Supplementary Plan pls. upload.

WA/7/19/RES - Lanes End, West Walberton Lane - Additional information request

PLOTS 4 AND 5
FLOOR PLANS AND
ELEVATIONS

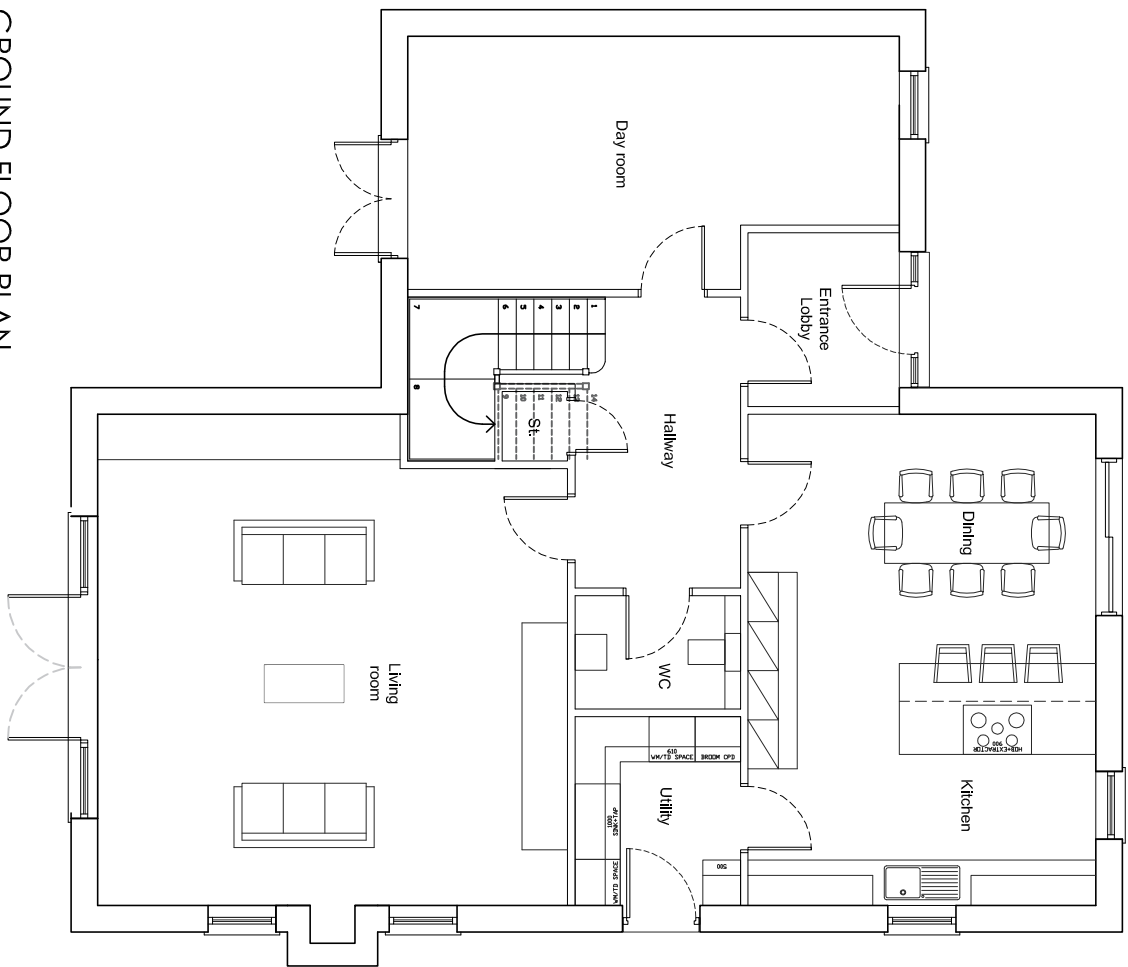
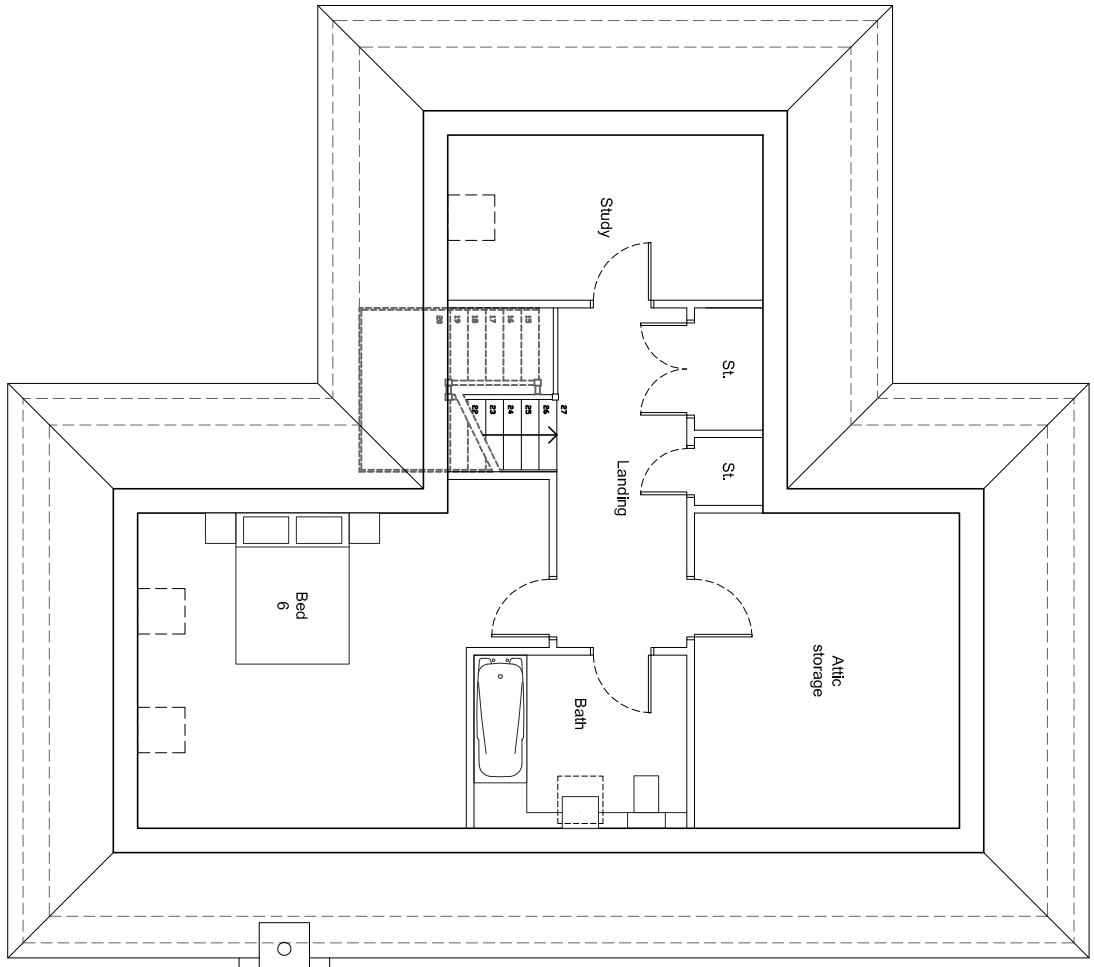
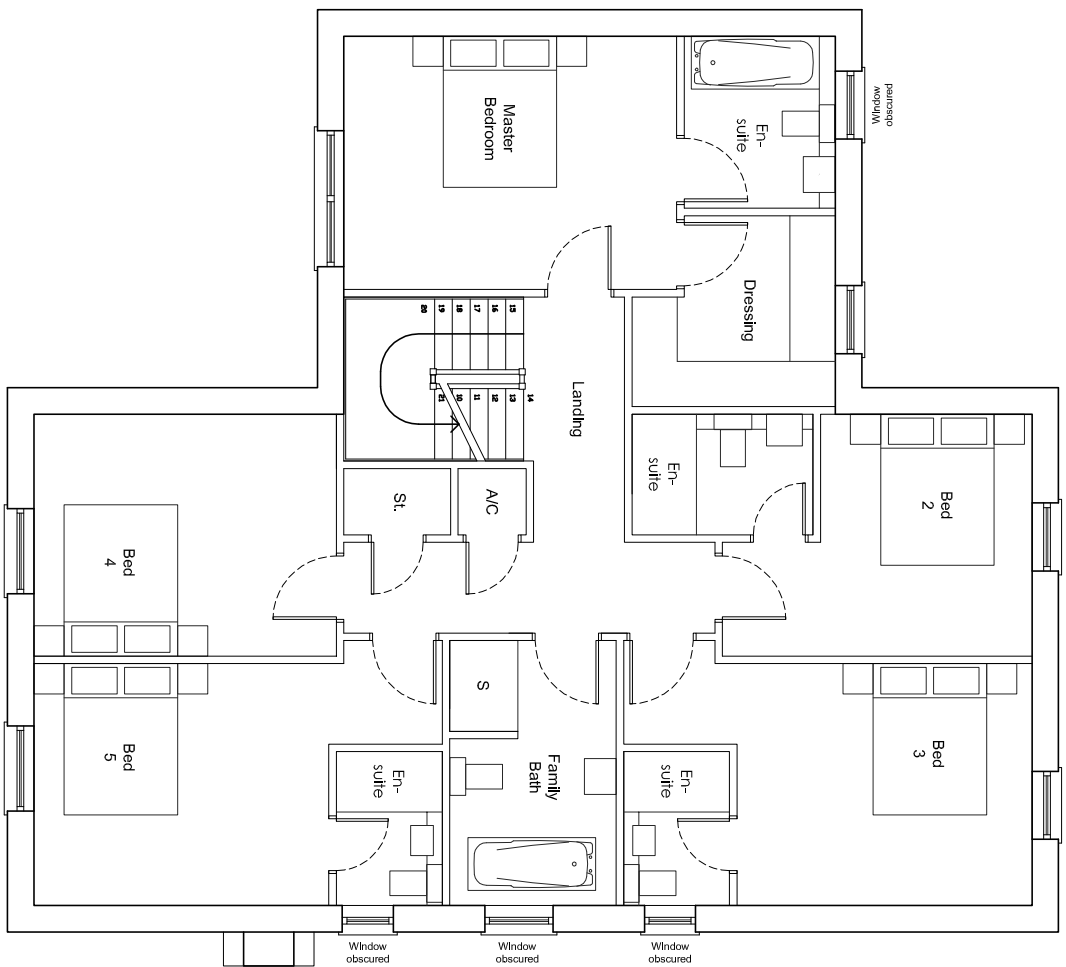
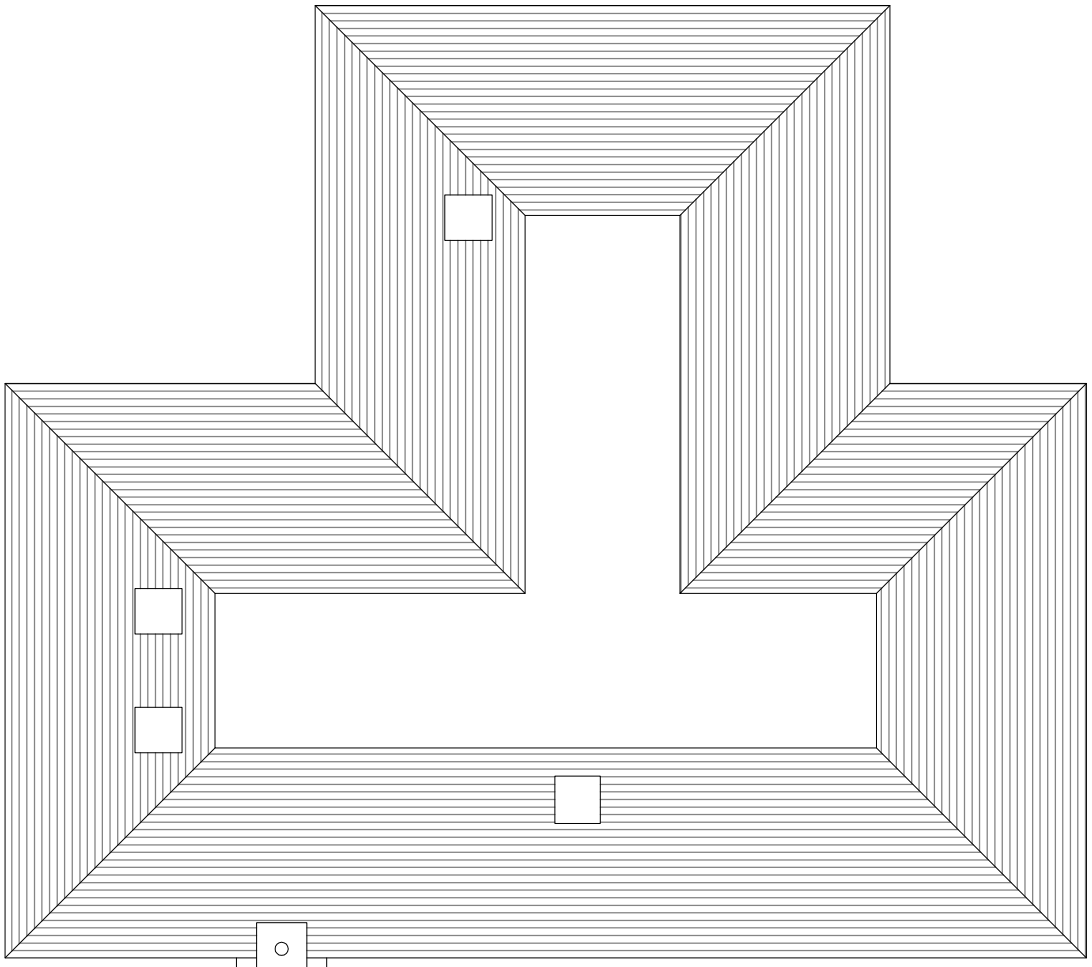
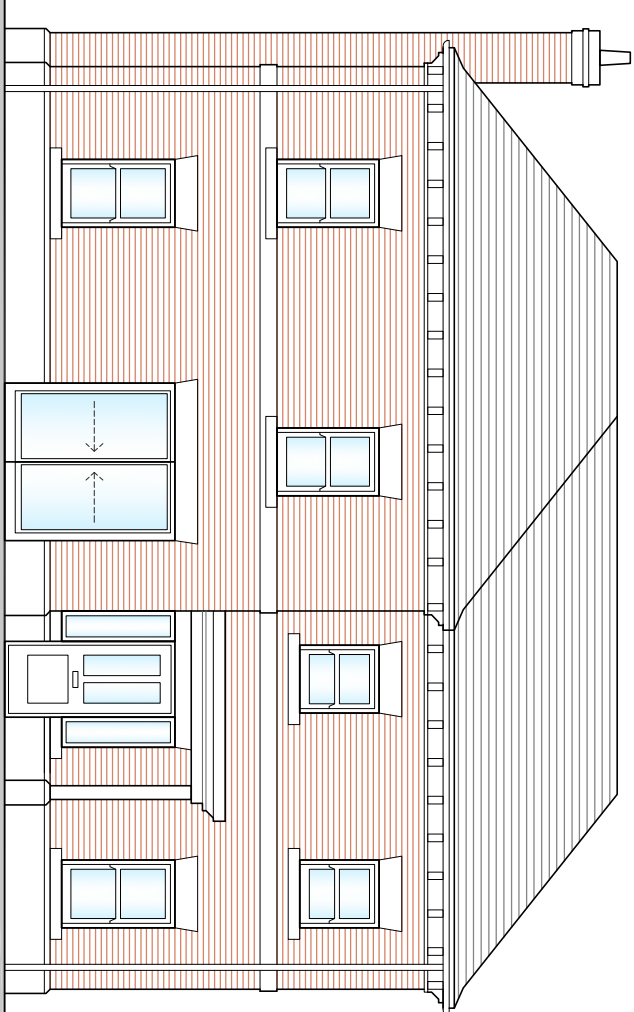
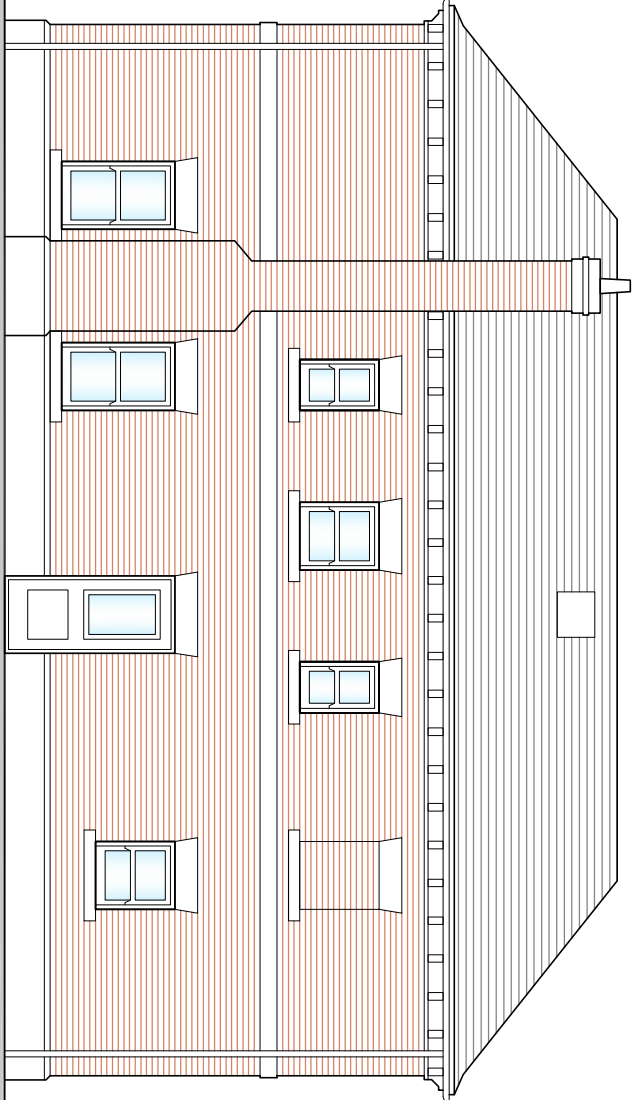
1. Amend the layout to ensure that a minimum of 9 metres exists on from blank gable end (or obscure glazed windows non opening below 1.7 metres in height) of nearest proposed house to gable end of 'Woodlands' which currently incorporates sole habitable room windows.
2. Remove second storey of houses/rooms in roof. 3 storey townhouses would not be acceptable in this location

2, we fail to see the merit in removing the room in the roof, this would have no impact on the height of the buildings and would result in empty lift spaces which would not allow for good use of space as per the NPPF. You will note from drawing 19-001-PL-03 all the dormers on houses 3-6 are in the south and therefore can not be seen from the front or any point outside the properties. Currently prosperities one and two have the dormers on the north but I would be happy to move these to the south so these are the same and none can be seen from Arundel road. I also would like to mention the design of white cottage next door that will have dormers in the roof and Richmond house which has velum windows in the roof. As previously mentioned the new ridge heights will be lower than the current house at Lanes end this can be seen in the scale drawings provided. If you could let me know if this is acceptable as if possible to avoid I would prefer not to have to appeal the reserved matters for this small item.
